Application: SSI 7485

I write regarding the proposed modification to M4-M5 Link, Mod 2 The Crescent overpass and changes to pedestrian infrastructure in North Annandale, Rozelle and Rozelle Bay Foreshore area.

Figure 4-2 Pedestrian and cyclist bridge infrastructure options

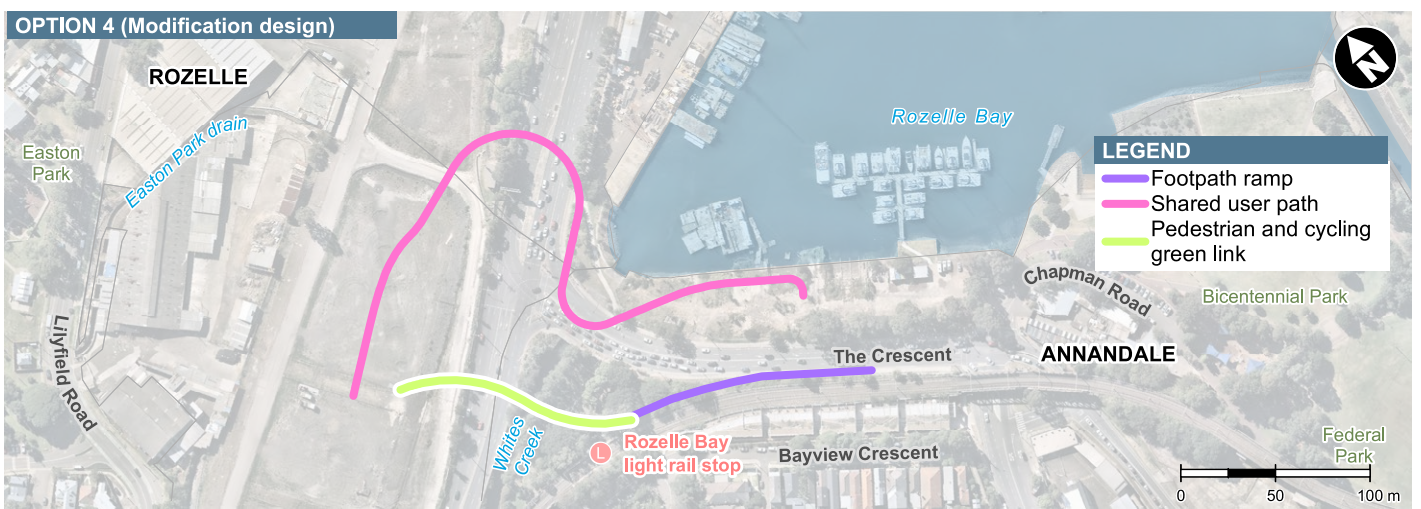
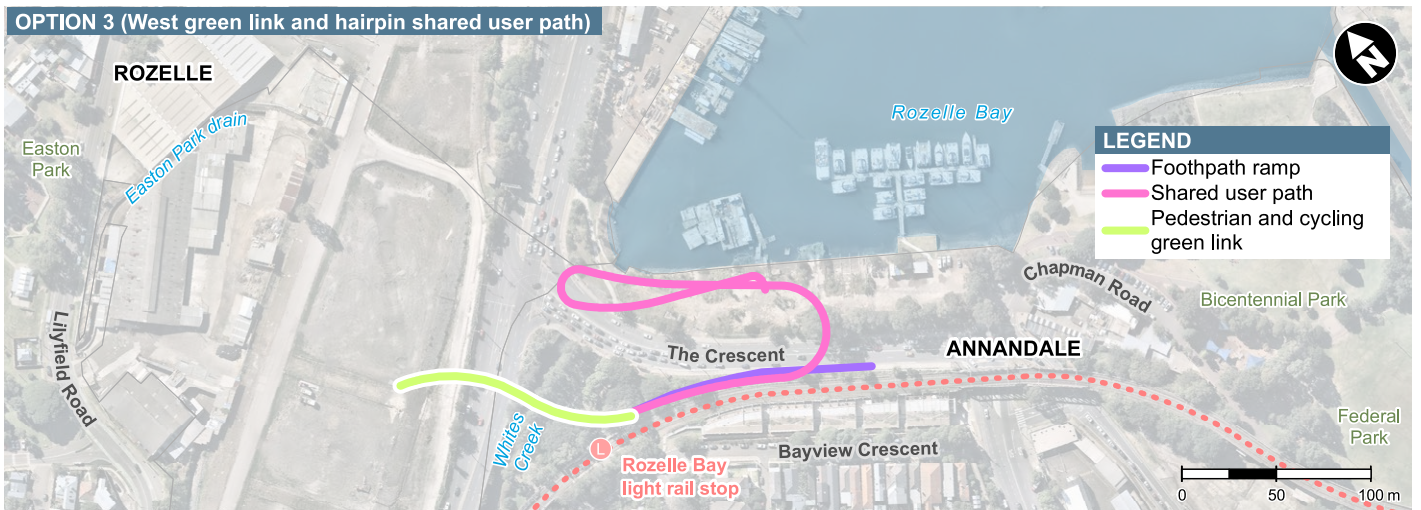
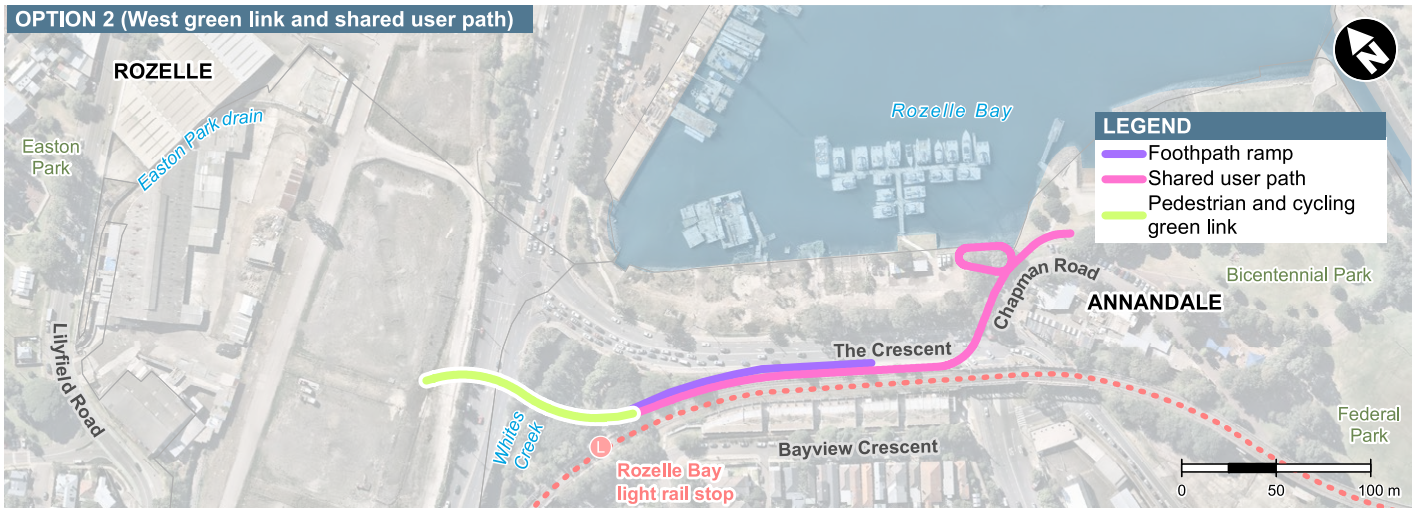
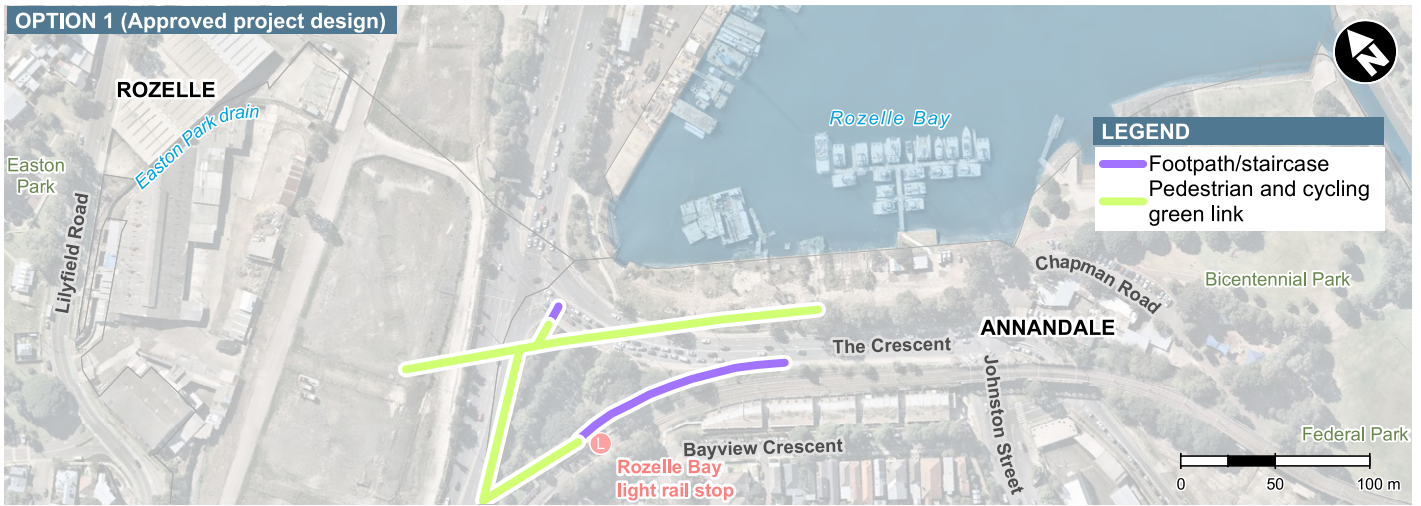
I request RMS work with the community to explore alternate design options to the proposed new car overpass design and the changed pedestrian and cyclist links. I am seeking the reinstatement of the safe, direct access from the approved EIS GreenLink to create a continuous green open space connection from the Rozelle Rail yards and Annandale to the foreshore. The GreenLink was more than just a walk way - it put people central to the design, maximising safety, and providing much needed accessible open space for the community now and into the future Bays Precinct design.

- The significantly reduced safety and increased risk for pedestrians and cyclists with removed access over The Crescent to Bicentennial Park and the increased traffic along Johnson Street.
- Being required to cross five sets of pedestrian lights at The Crescent as my option to reach the foreshore from Annandale or from Rozelle Bay light rail stop.
- Removal of direct active links to the foreshore, cutting the community off from the area and the proposed revitalisation of the entire Bays Precinct, including linking the Light Rail and Bus stops to a Ferry wharf and Metro station.
- Urban and landscape design that is being built before a finalised Masterplan for the area.
- Traffic changes that limit movements around the suburb and create further congestion in the local streets of Annandale, Forest Lodge, Glebe, Lilyfield and Rozelle with no planning to deal with these.

- Reinstall the GreenLink connecting communities and green open space from Rozelle to Bicentennial Park
- Relocate and design pedestrian and cyclist connections that are continuous, safe and direct.
- Design the modification infrastructure and active links in response to the character of the suburbs, the location of the foreshore and its potential future development.
- Provide pedestrian and cyclist paths that maximise people safety and do not force them onto busier streets, unsafe concrete plazas and caged walkways.
- Integrate active and direct connections to all active transport - including the future Metro West and Foreshore Ferry Wharf

- A. having low gradients for bicycles and prams
- B. having bicycle/pedestrian access which is convenient for movements among Rozelle, foreshore, Annandale
- C. having non-threatening crossings, even when there are traffic lights (Even now I am careful in crossing in front of James Craig triple lanes.
